**Consultation Response from Mark Berry KC,
Highways Development Management**

2022/92428 4, Back Lane, Grange Moor, Huddersfield, WF4 4EJ

**Outline application for demolition of existing dwelling and garage and erection of residential
development (8 semi-detached dwellings)**

A General Updates		08/12/22	MO	-
Rev	Description	Date	By	App'd
Project	Proposed Residential Development	Project no	22.004	Date
	4 Back Lane, Grange Moor, WF4 4EJ			20/05/22
Drawing Title	Site Plan as Proposed	Scale @ A3	1:500	Drawn by
			MO	Appr. by
Client	Nigel Westerby	Drawing no	AL0002	Rev
				A

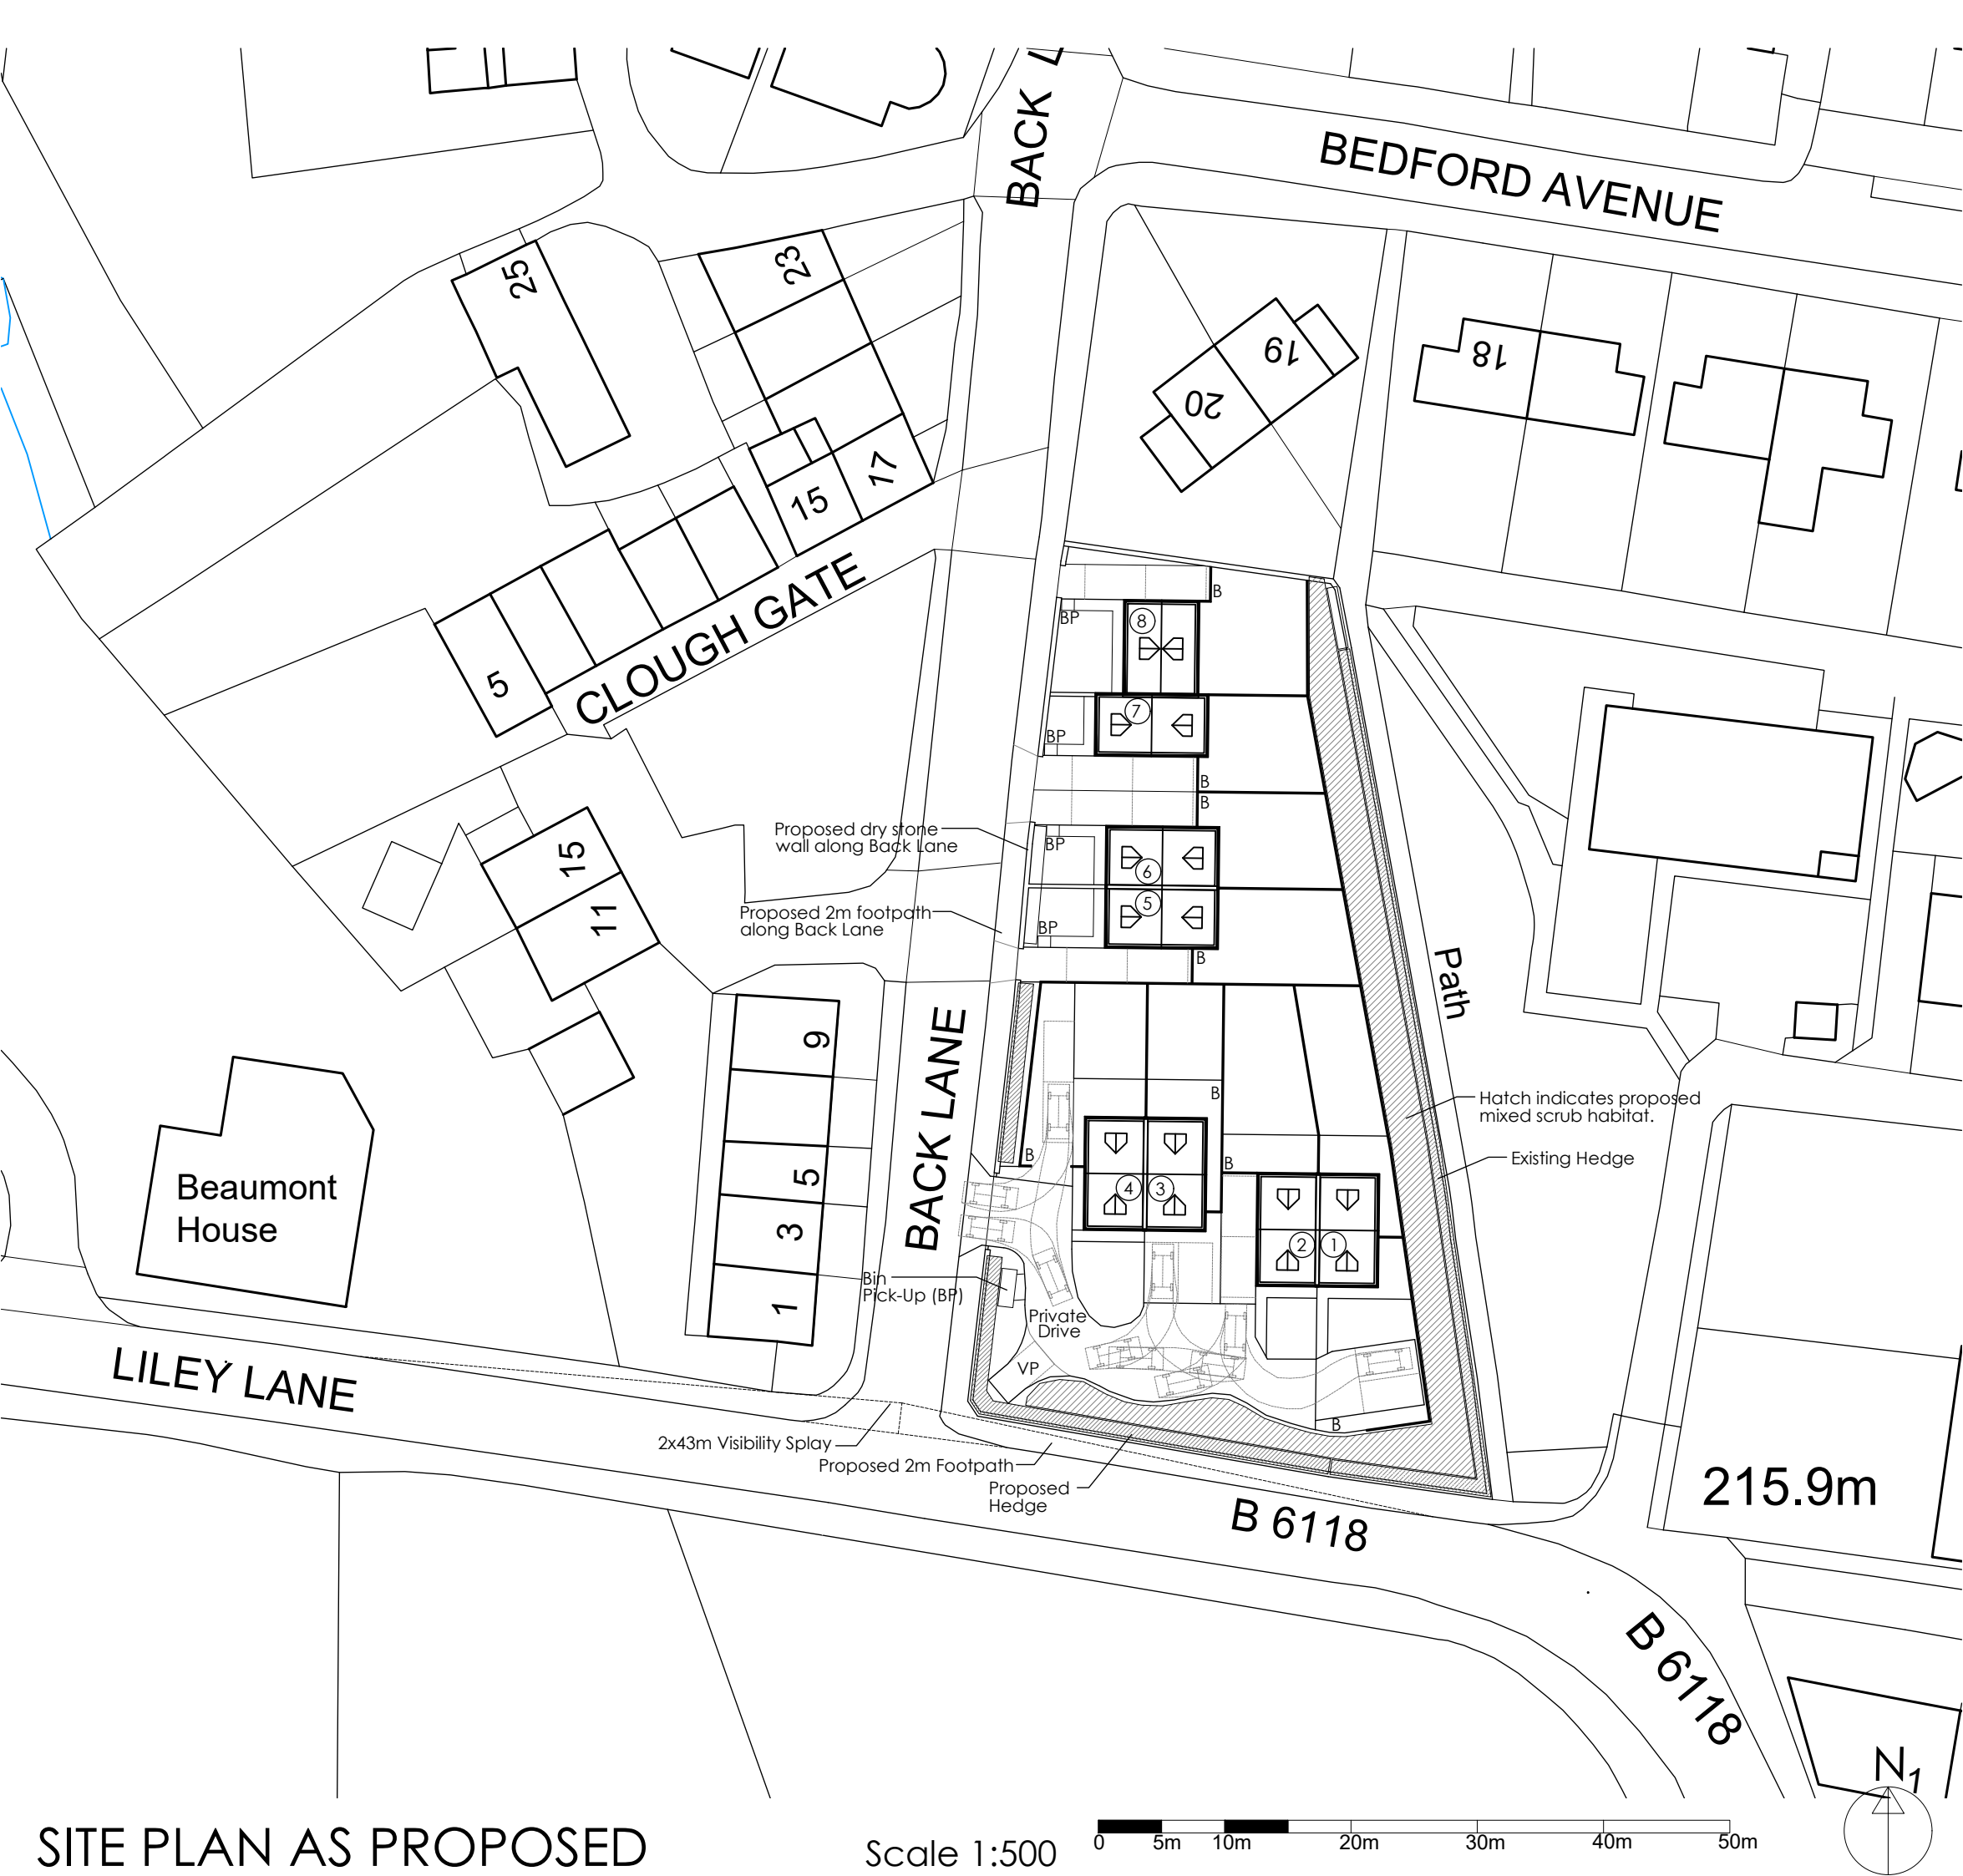
The applicants have provided revised plan number AL0002 rev A showing the footway to the Liley Lane site frontage widened to 2.0m a 2.4 x 43m visibility splay at the Back Lane/ Liley Lane junction bin collection points to plots 5 to 8 and the proposed shared private driveway to plots 1 to 4 widened.

These proposals are now considered to be acceptable to Highways Development Management.

Notwithstanding the details shown on the approved plan, the development shall not commence until a scheme detailing the provision of a 2.0m wide footway to the Liley Lane frontage of the development site, construction specification, surfacing, drainage and kerbing including the relocation of existing street road signs and associated highway works has been submitted and approved in writing by the Local Planning Authority. The development shall not be brought into use until the approved scheme has been implemented and thereafter retained throughout the lifetime of the development.
